Subject: RE: Y/9818/RES and Y/97/18/DOC

Laura Gibbons, MEng, GMICE
Engineer (Drainage & Coastal)

Comments on the revised drainage and landscape proposals:

Scale NTS @ A1	Date APR 19	Designed SG
Drawn TSB	Checked SG	Approved LH
Job No 18-070	Drawing No 18-070/109	Rev C

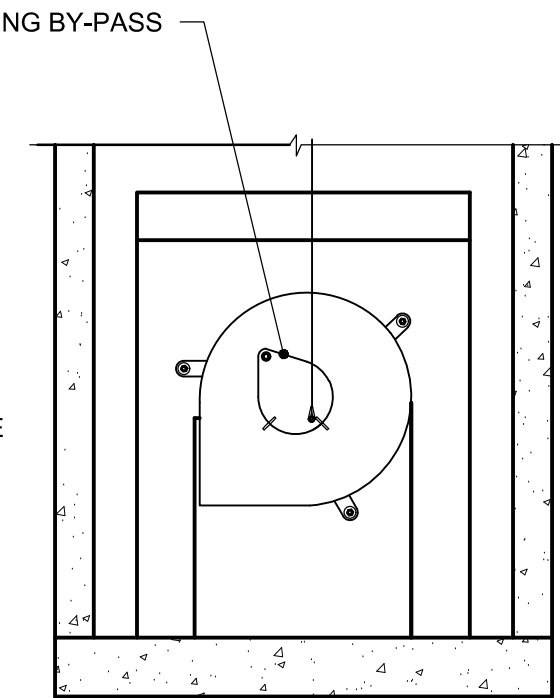
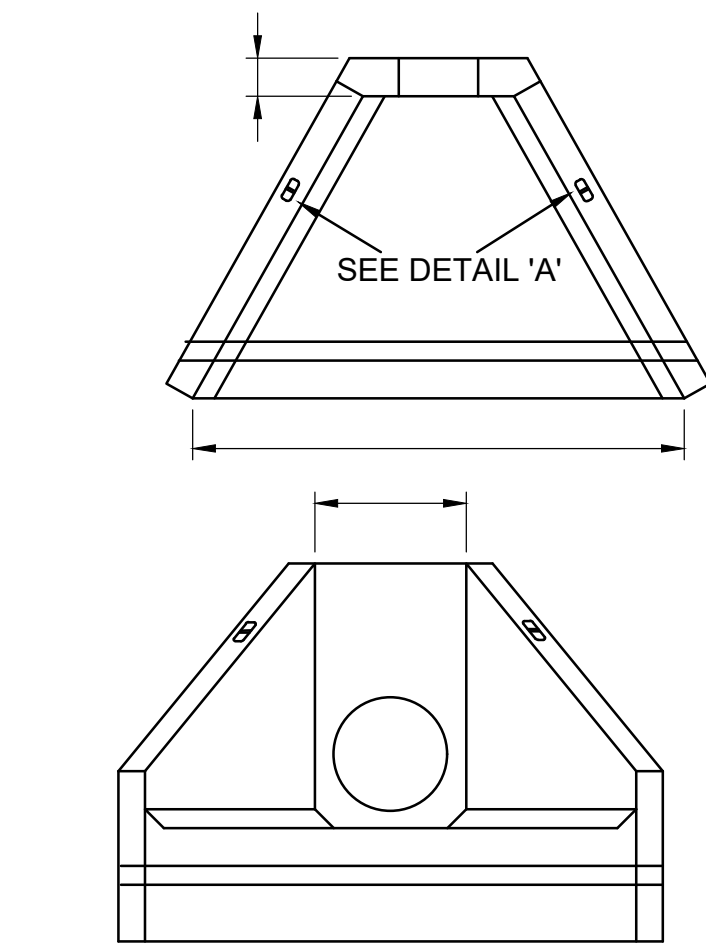
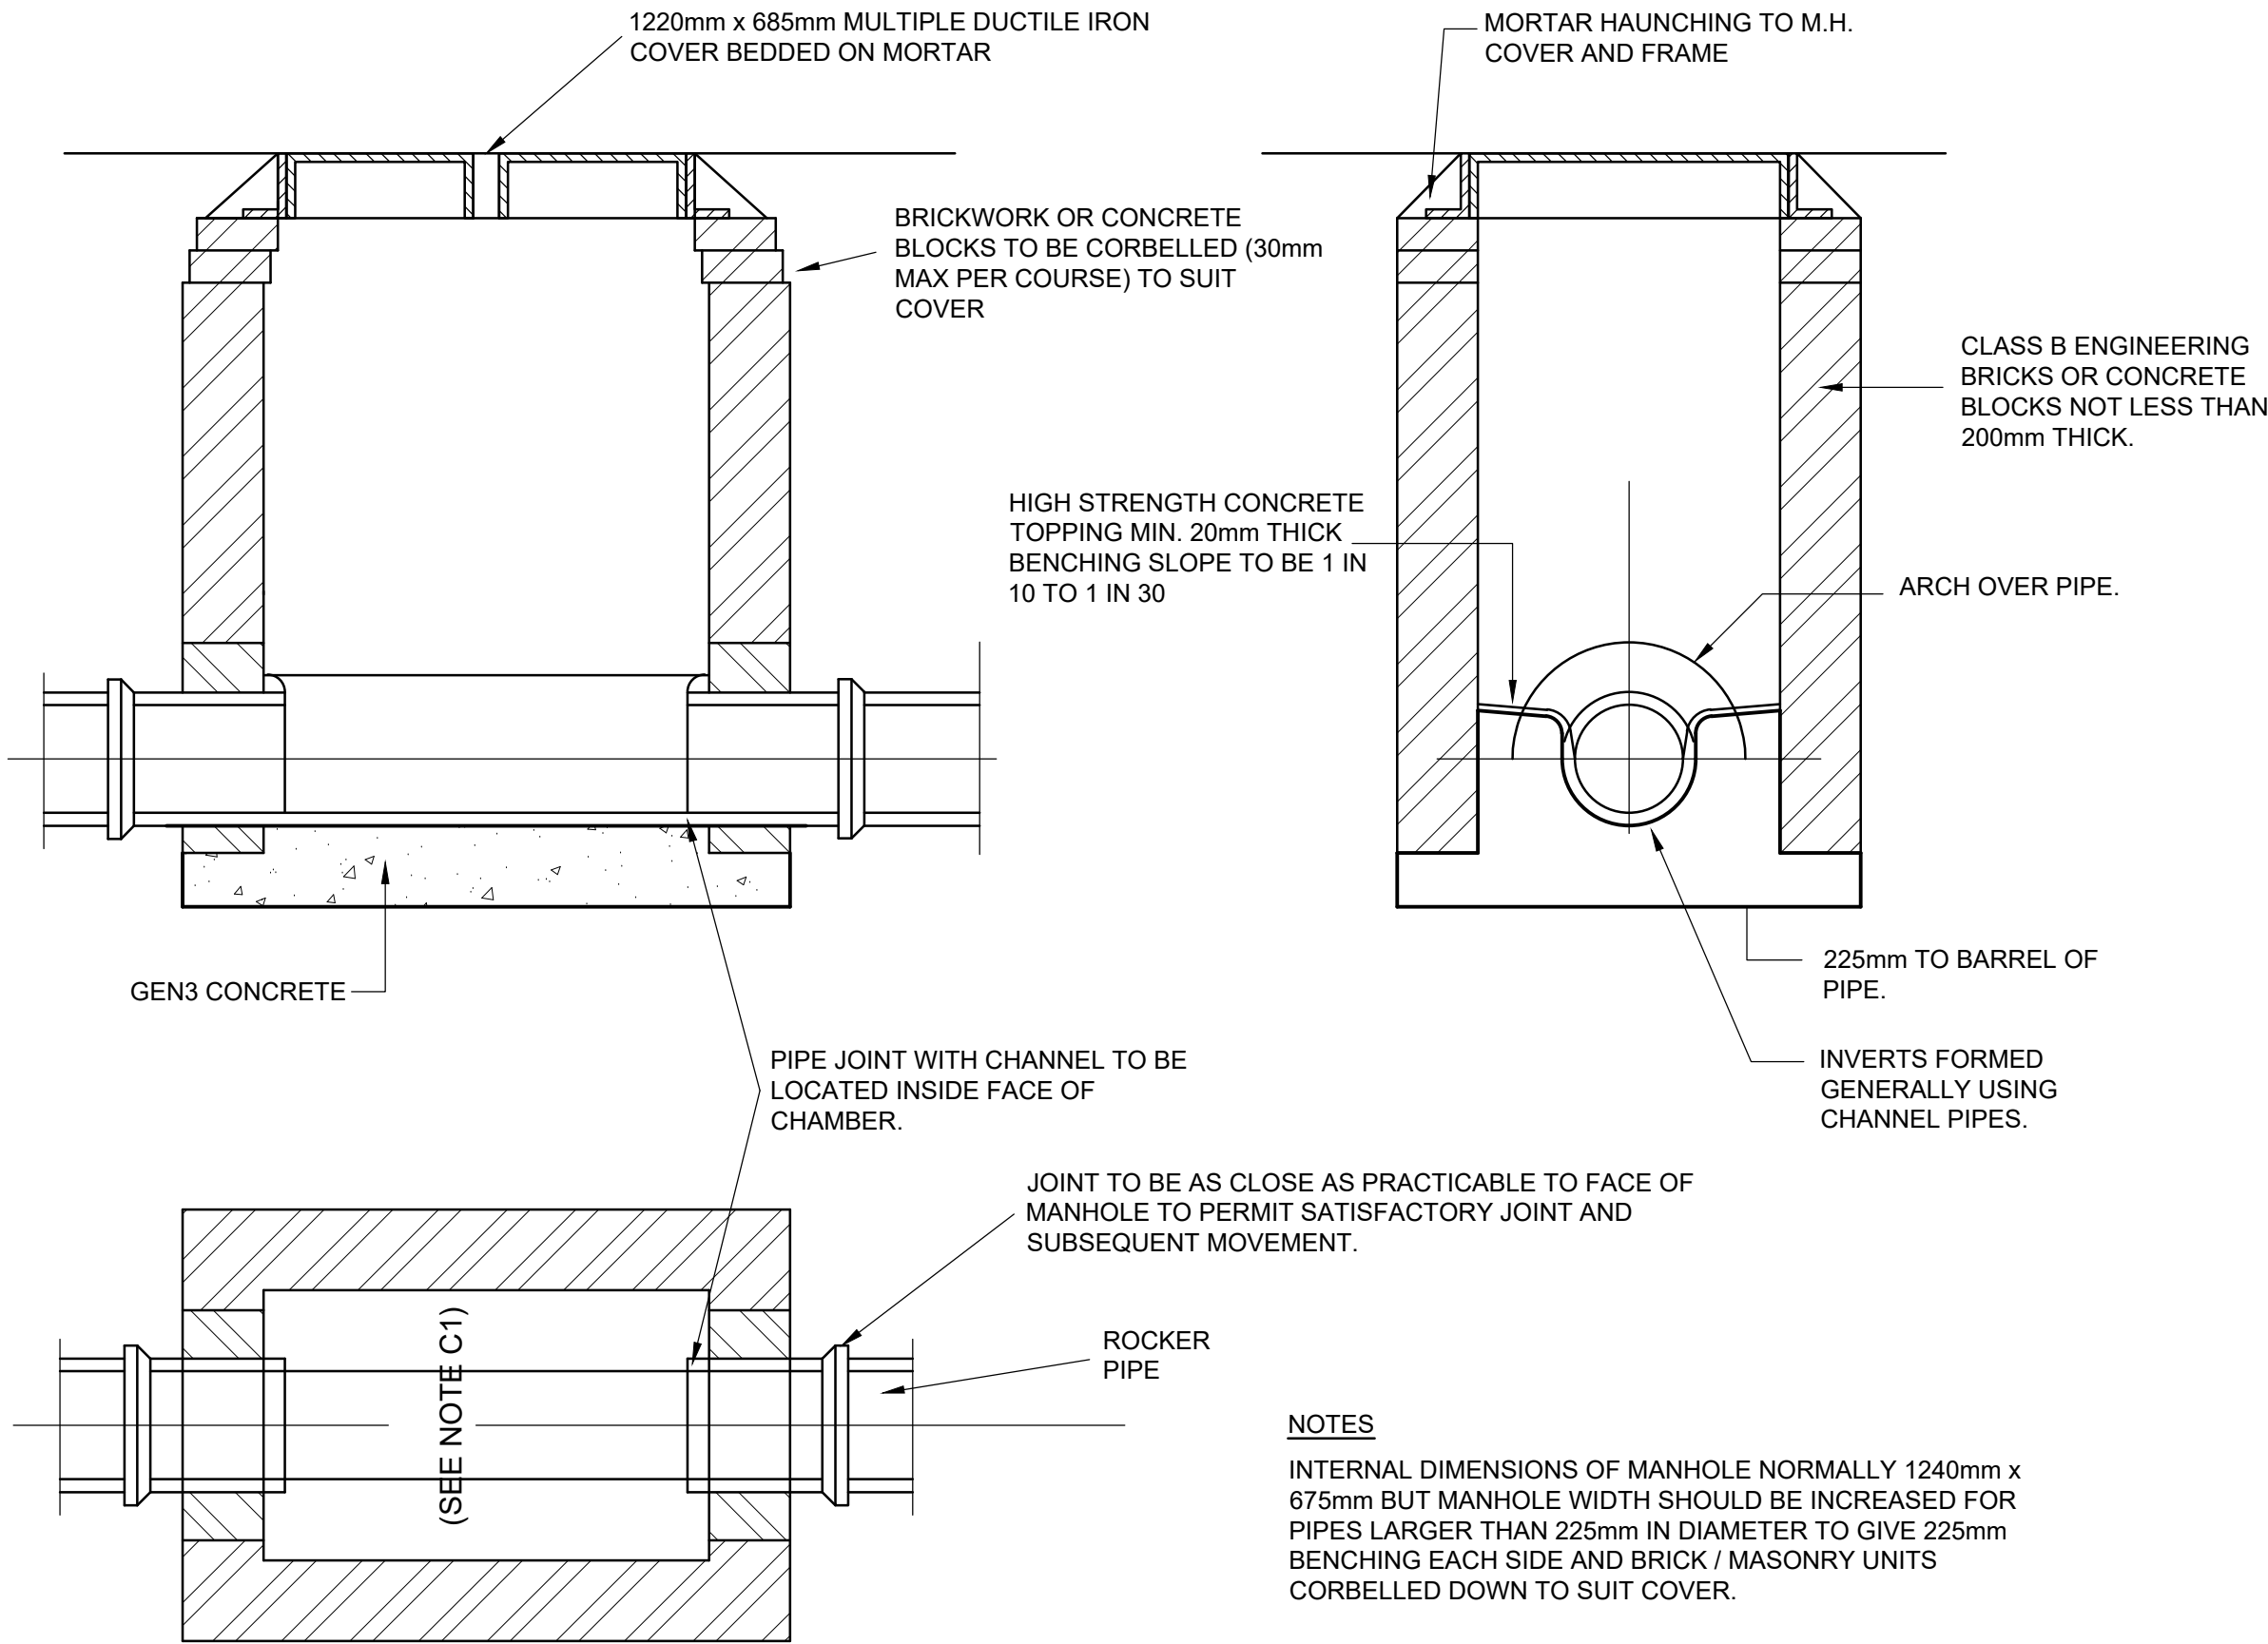
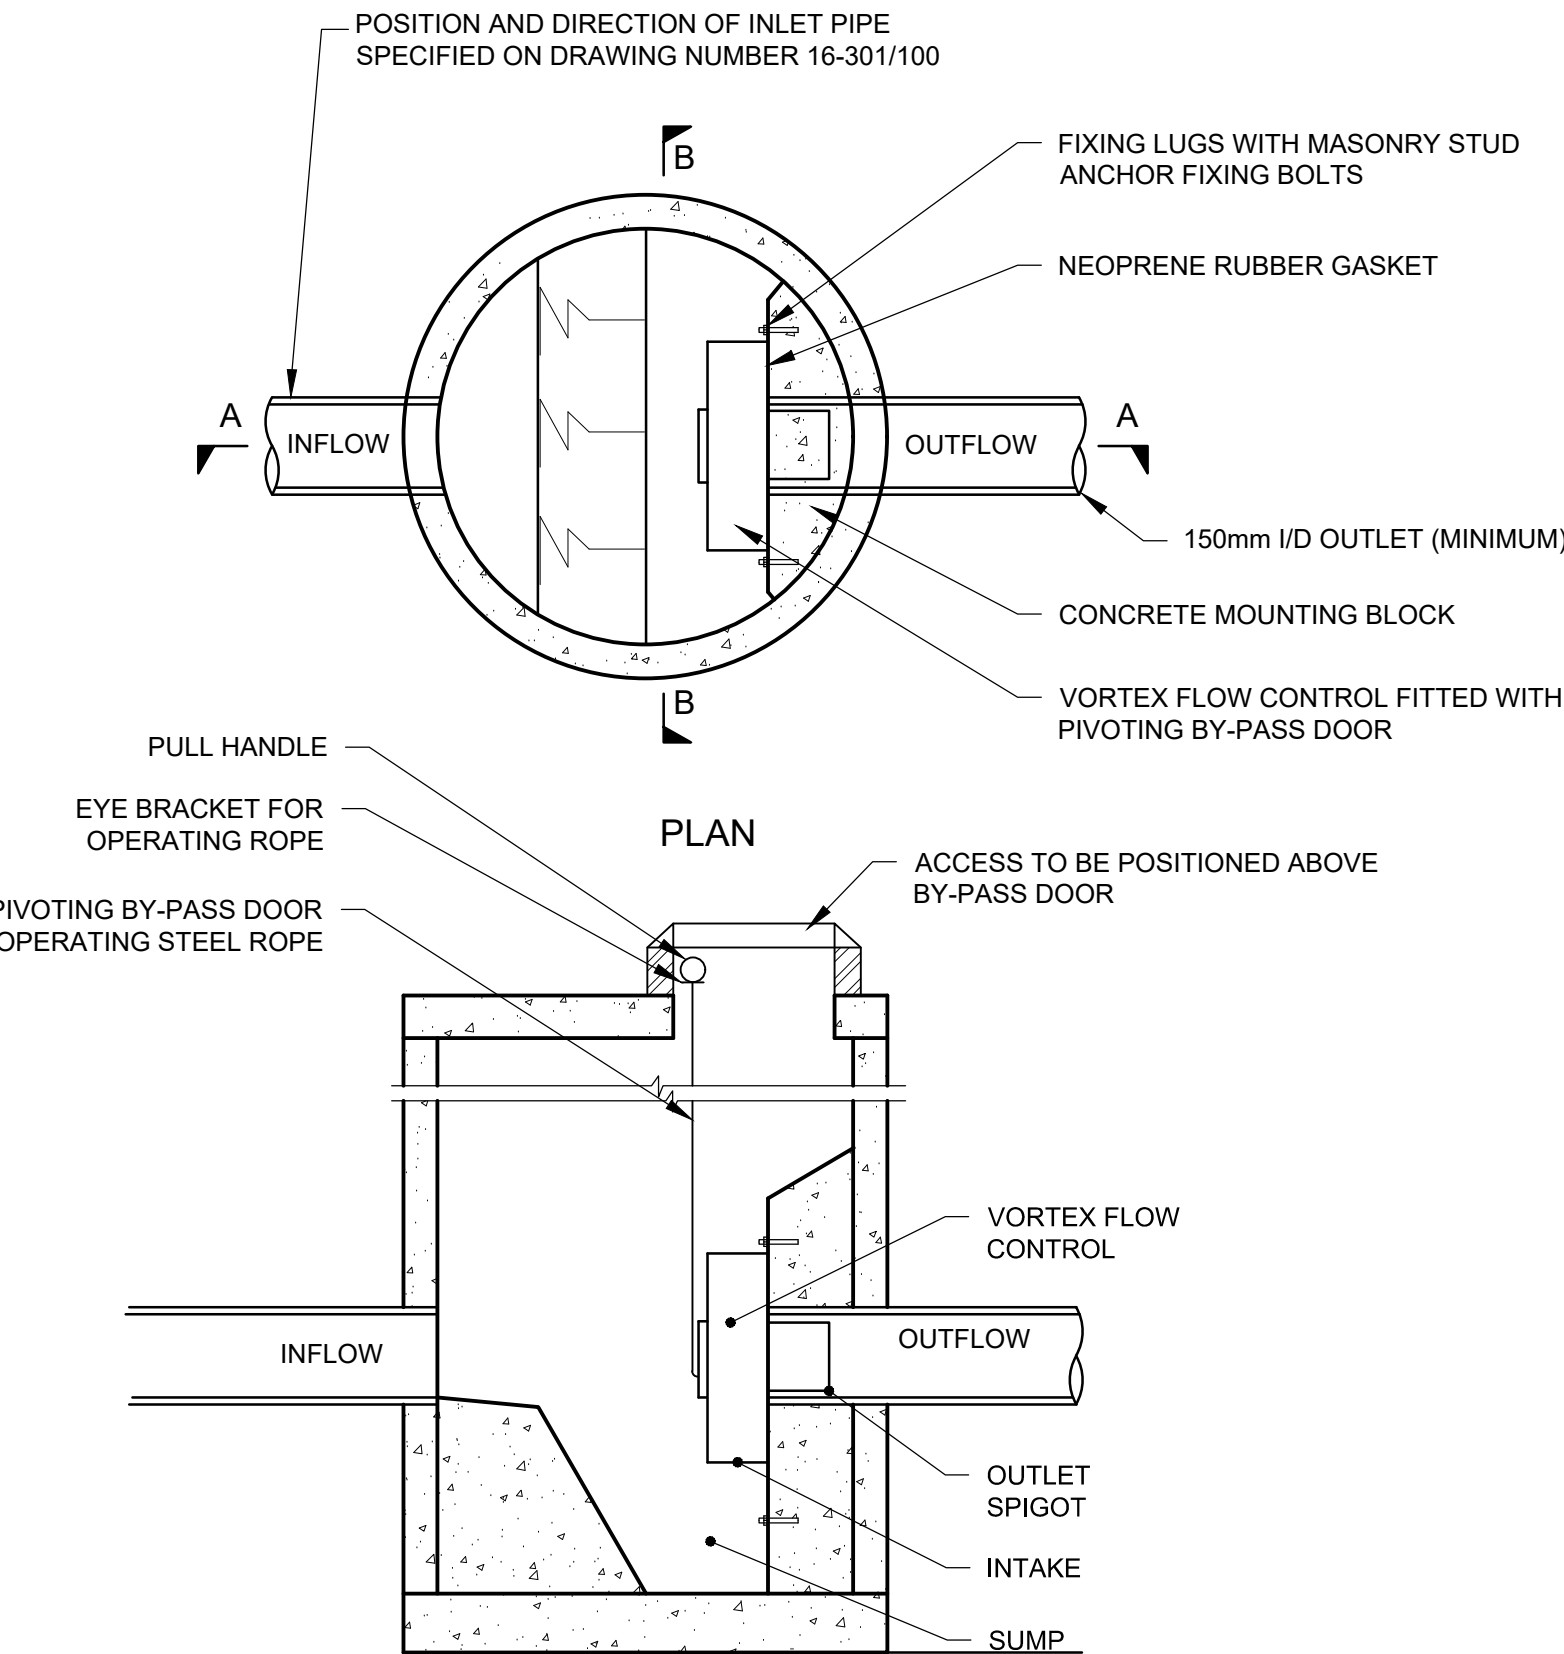
4. Headwalls are set 150mm above ditch level. Refer to the updated plan provided. *Outfall invert levels are shown to be 150mm above a localised bed level. Please acknowledge that regrading will be carried out to remove the high areas of ditch bed downstream and ensure that a smooth gradient is provided.*

5. Proposed invert levels of outfalls to ditches appear to be low in comparison to surrounding bed levels. A minimum of 150mm must be provided between the invert level of outfall and ditch bed level. The site is quite constrained as we have had to look to achieve outfalls without impacting significantly on pipe depths in the road (for adoption), meeting highway adoption standards and building regulations/level design requirements, existing tree retention at boundaries, minimising roof heights etc. We have amended the outfall pipe diameter and gradient and pulled the headwalls back/provided a new short section of ditch prior to connecting the site to the existing ditch. This improves the level difference by around 50-100mm. *Site specific detail drawings of outfalls need to be provided. 150mm is our absolute minimum requirement.*

3. Further site investigation/soakage tests have been requested. Please see associated sketch sent to geotechnical engineers within the link provided.
4. Headwalls are set 150mm above ditch level. Refer to the updated plan provided.
